Re: Land adjacent to the Load of Hay Public House, Villier Street, Uxbridge UB8 2PU (ref: 201514/APP/2021/1582)

We write on behalf of our client Villier Street Developments Ltd to respond to the objections received in relation to planning application (ref: 201514/APP/2021/1582) for the:

"Construction of the dwelling with associated amenity space, refuse storage and parking provision, involving the extension of an existing vehicular crossover".

Proposed South Elevation

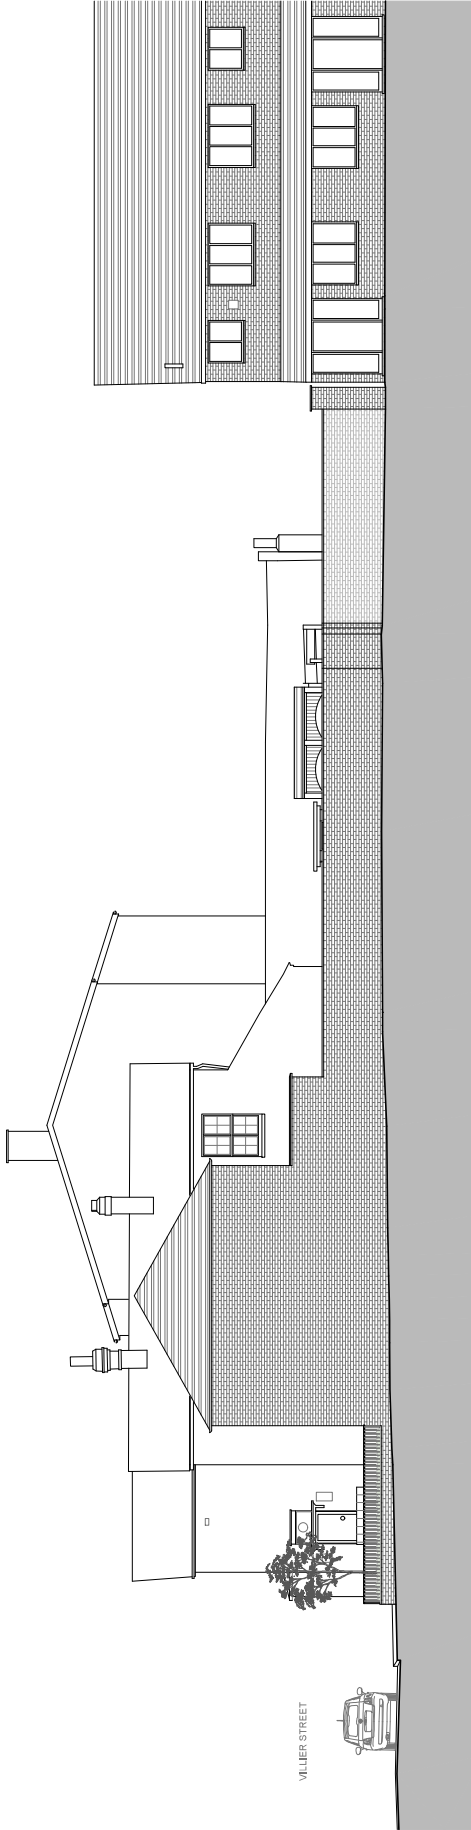
We would like to take this opportunity to respond to Conservation Officer's (CO) comments received on 14th June 2021. The design has been amended to include:

- The provision of a brick pier and railing to the front of the property; and
- Two additional planters located by the residential access.

The scheme has been revised in order to appropriately respond to the CO comments. As stated within the CO comments, the dominant boundary treatment along Villier Street is defined by low-rise brick walls. Therefore, the inclusion of a brick pier and railing to front of the property is in keeping with the character and appearance of Villier Street. An additional planter has also been located by the residential access which will create a symmetrical entrance path to the front door and will soften the front boundary. The revisions positively respond and engage with the surrounding conservation area and further demonstrates that the proposed scheme would enhance the conservation area.

Drawing Title
Proposed Ground Floor Plan

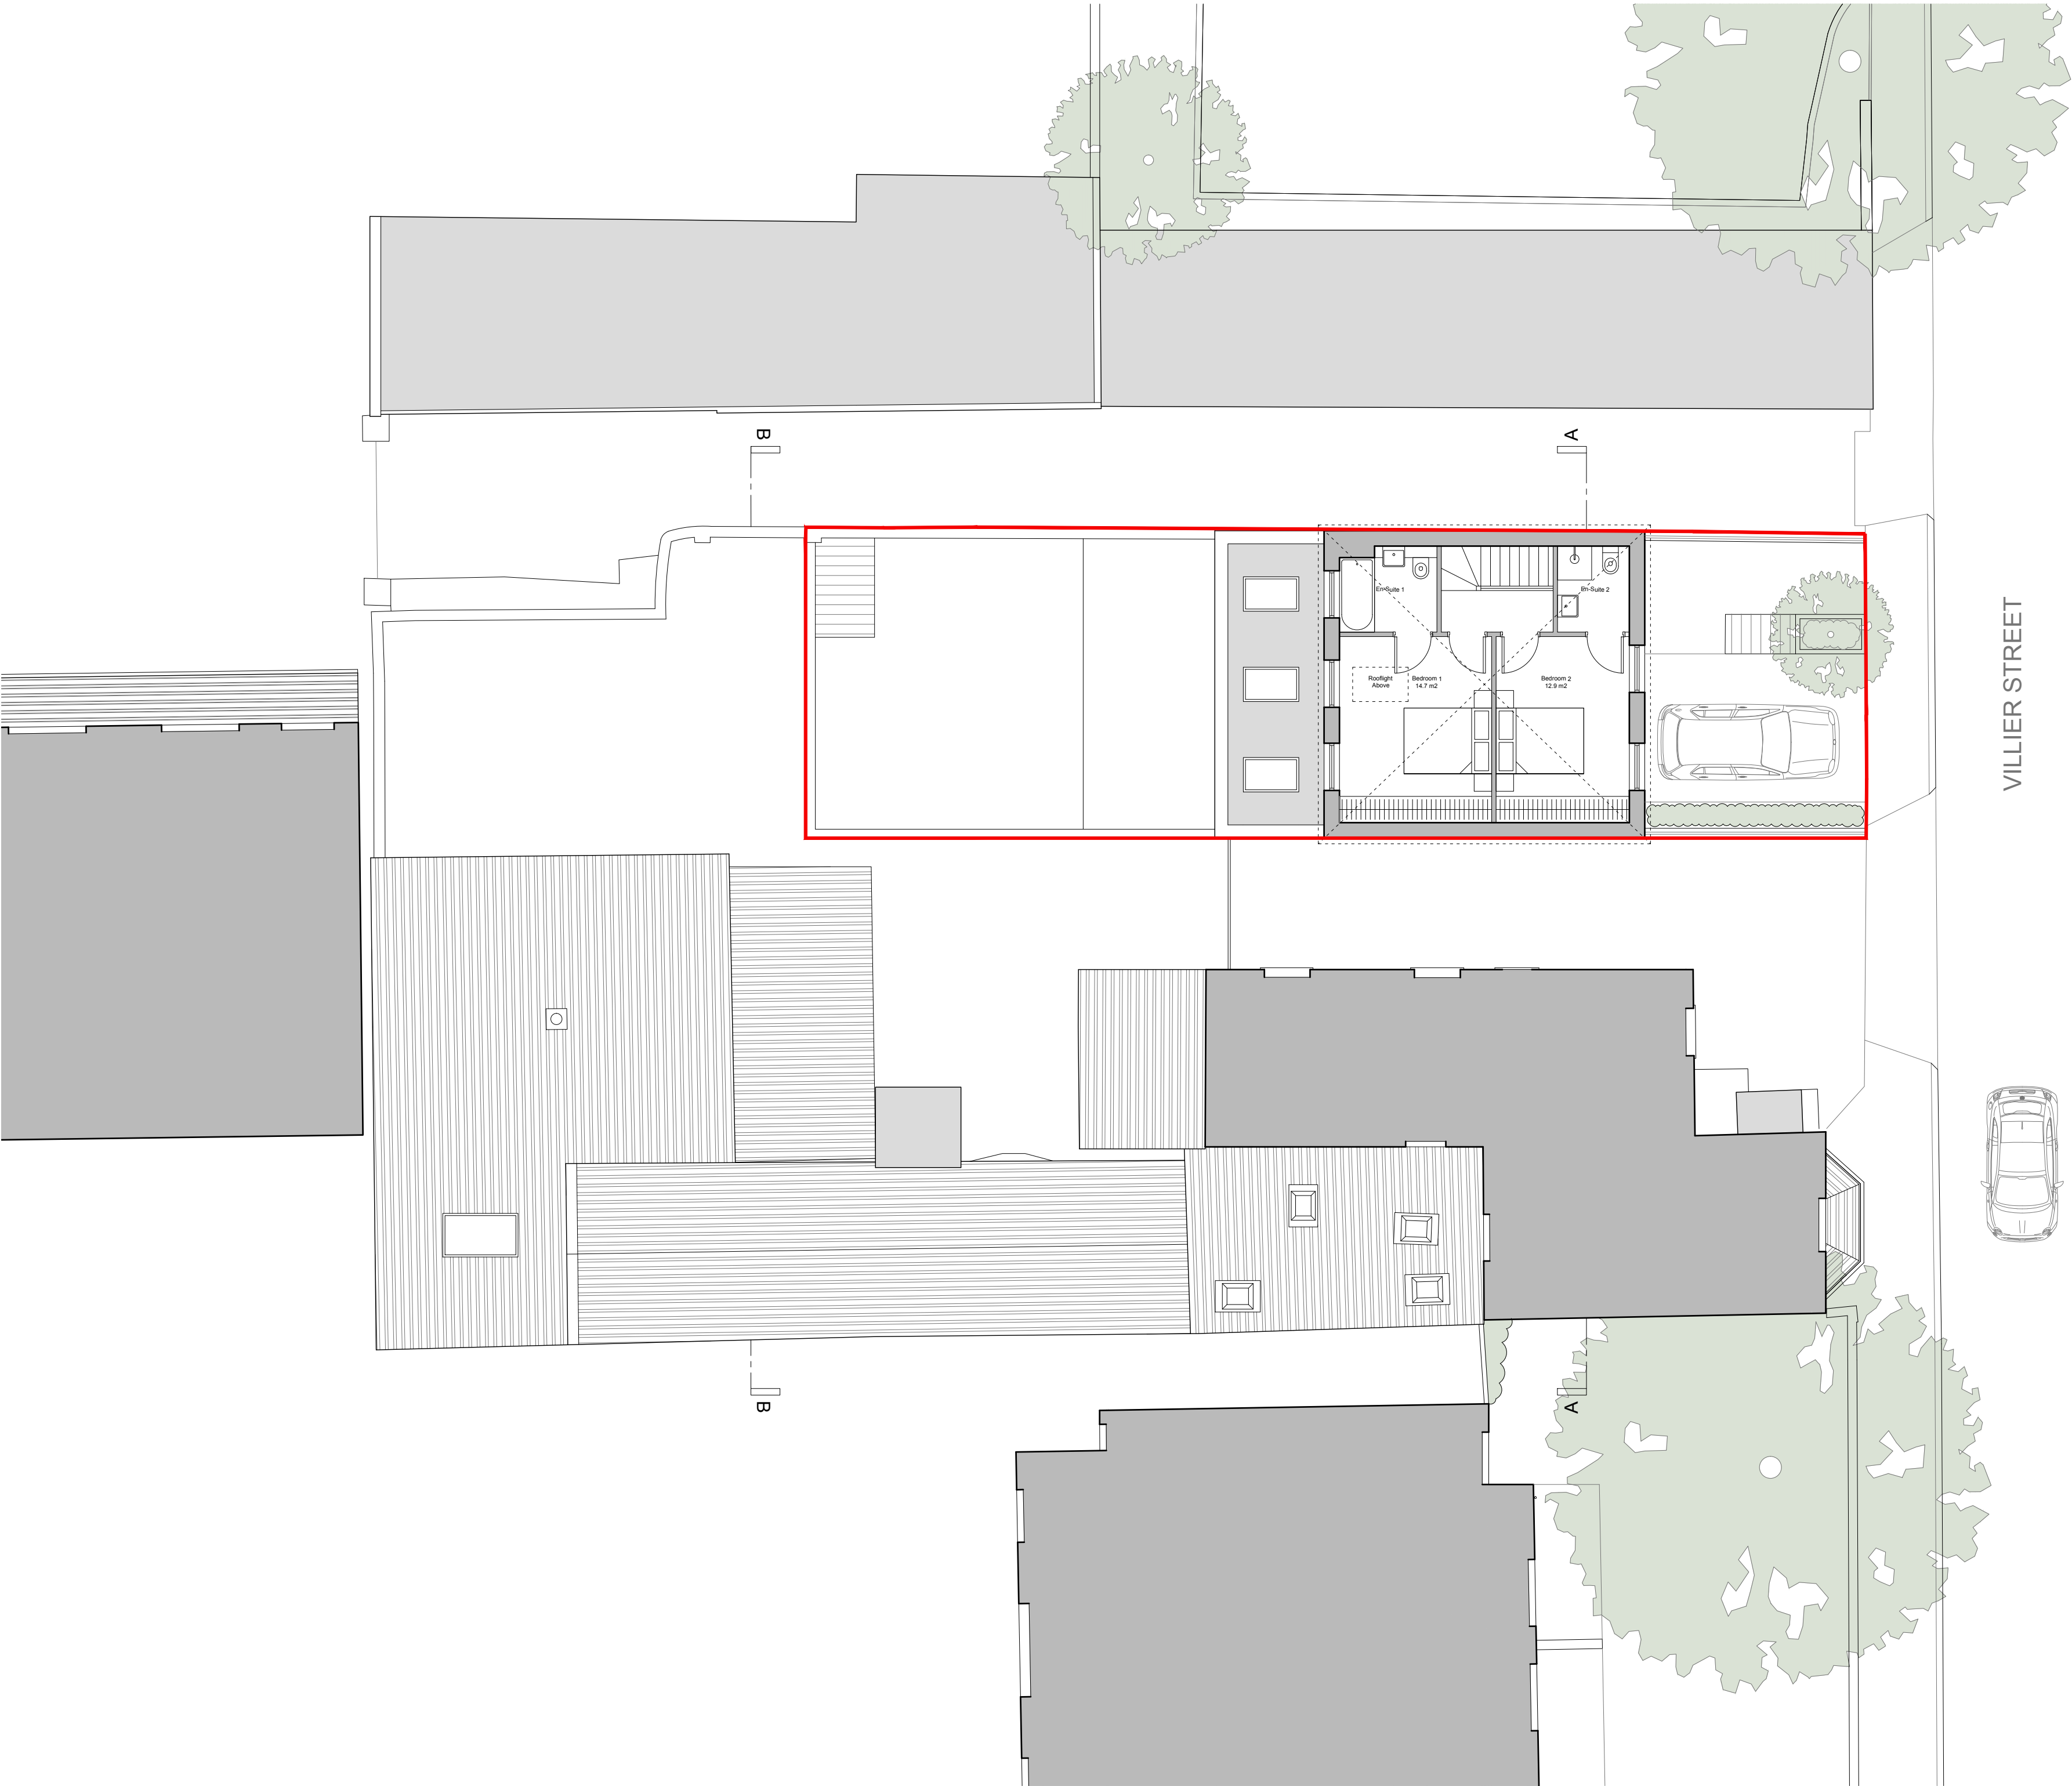
In relation to the proposed bin store, it is clear from on-site observations that properties to Villier Street do not have formal arrangements for bin storage. Many properties, including those with and without side access, store rubbish bags / bins on an informal basis in the front garden of their properties. The proposals have sought to provide a well-designed alternative to this type of visual clutter, and the placement is considered discrete given that it is set further back into the depth of the front garden. Nevertheless, the applicant has sought to address concerns relating to the front boundary treatment by providing an additional railing to the side boundary and front boundary including an additional plant by the entrance. The railing would be erected at less than 600mm in order to prevent any potential impact on visibility splays.
